**Town & Country Planning Act 1990 (as amended)
Town & country Planning (Development Management Procedure) (England) Order 2015
Application for Planning Permission for Works or Extension to a Dwelling**

Development Two Storey Side Extension, Loft Conversion, Enlargement of Parking Area and Crossover

Location 16 Arundel Road Angmering

DRAWING	SCALE
BLOCK PLAN EXISTING	1/200
DATE: JANUARY 2019	
DRAWN: T. Murray	
DRAWING: 19/01/3	REVISION:

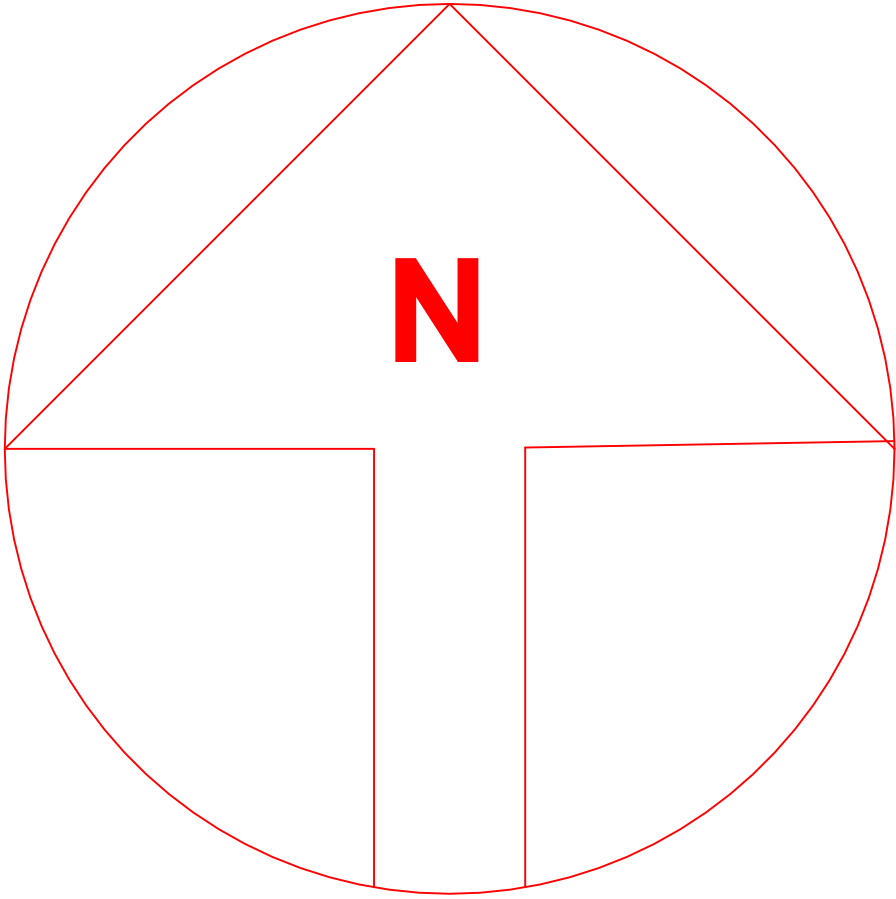
Block Plan

Please submit 1 electronic or 3 paper copies of a block/site plan which includes all dimensions from the proposed extensions to the site boundaries. At present a dimension is required from the proposed extension to the side boundary. Further details of what must be included on the plan can be found in the National Validation Requirements.
